MEMORANDUM

EPC Project No.: PPR2315

Re: Super Star Carwash – Claremont Business Park 2 – Drainage Compliance Letter

C5.2

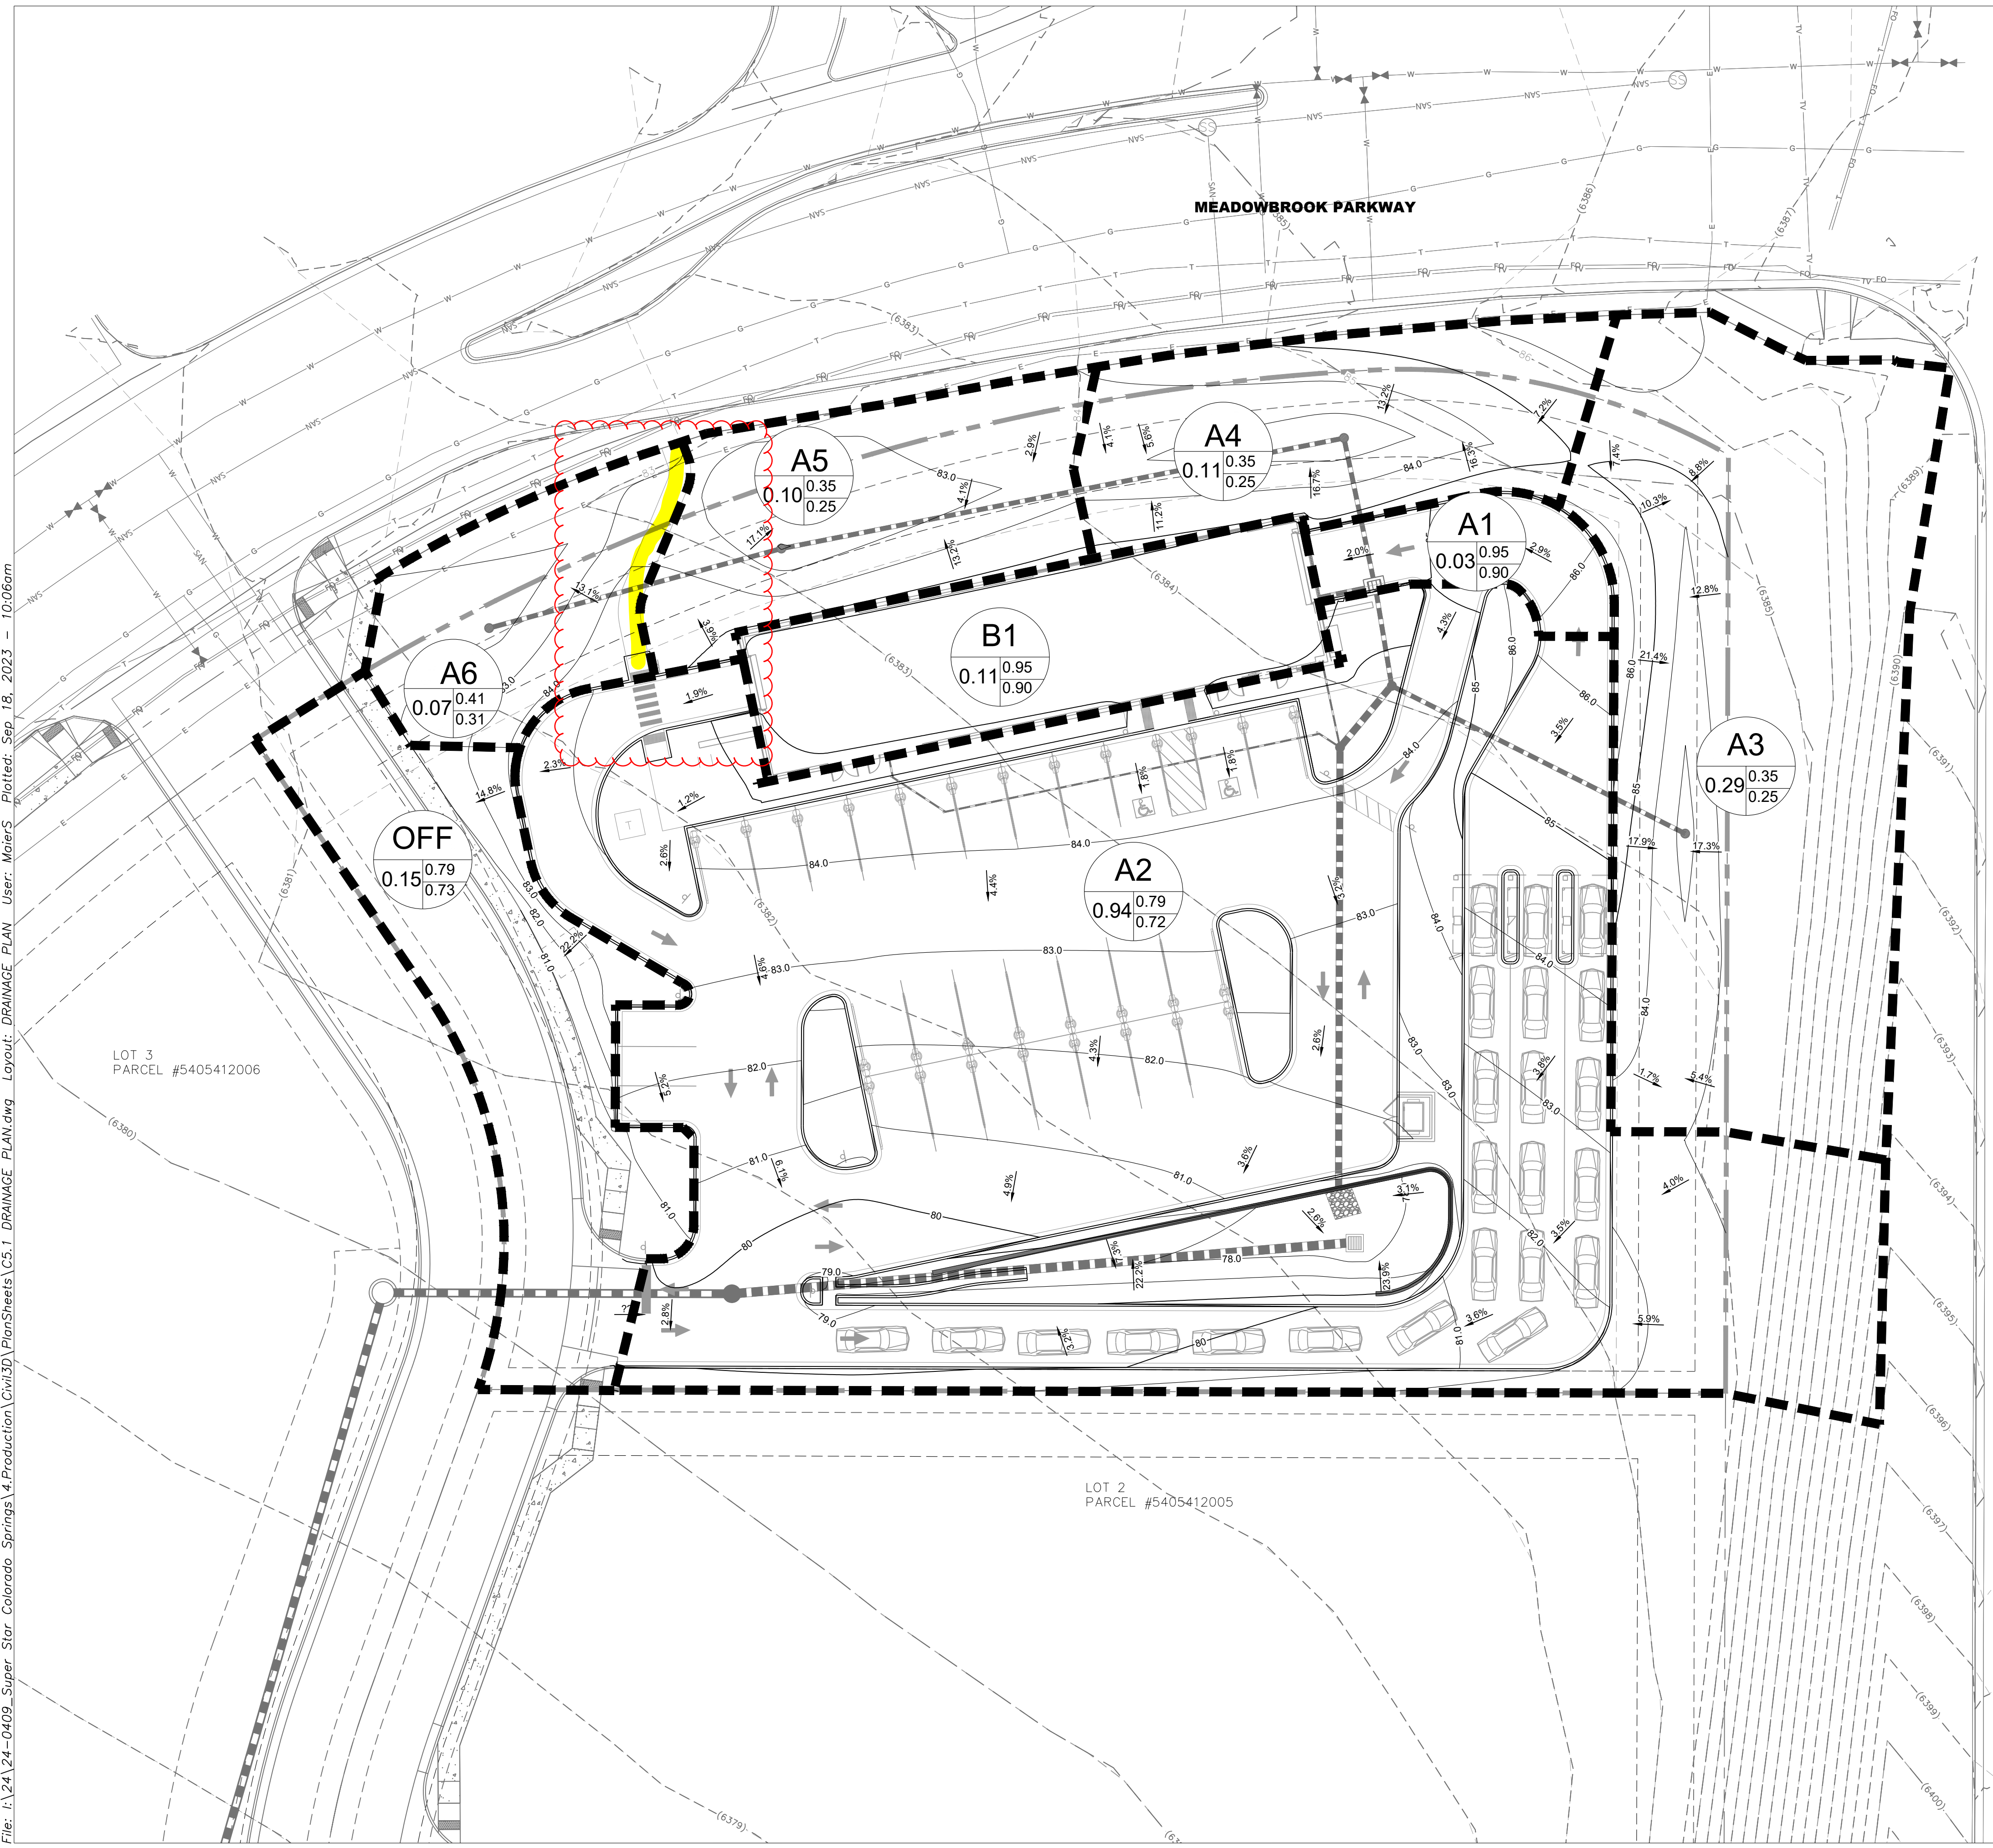
Please update report in accordance with ECM 4.5
The FDR for VR233 has not been approved yet.
Please include drainage map showing basins for the lot

discuss existing and proposed basins in the text. including flows, impervious areas, WQ treatment for each basin, and how flows will be directed to the WQ facility. Discuss the existing detention facility and show location on a figure.

provide a figure for existing and proposed basins.
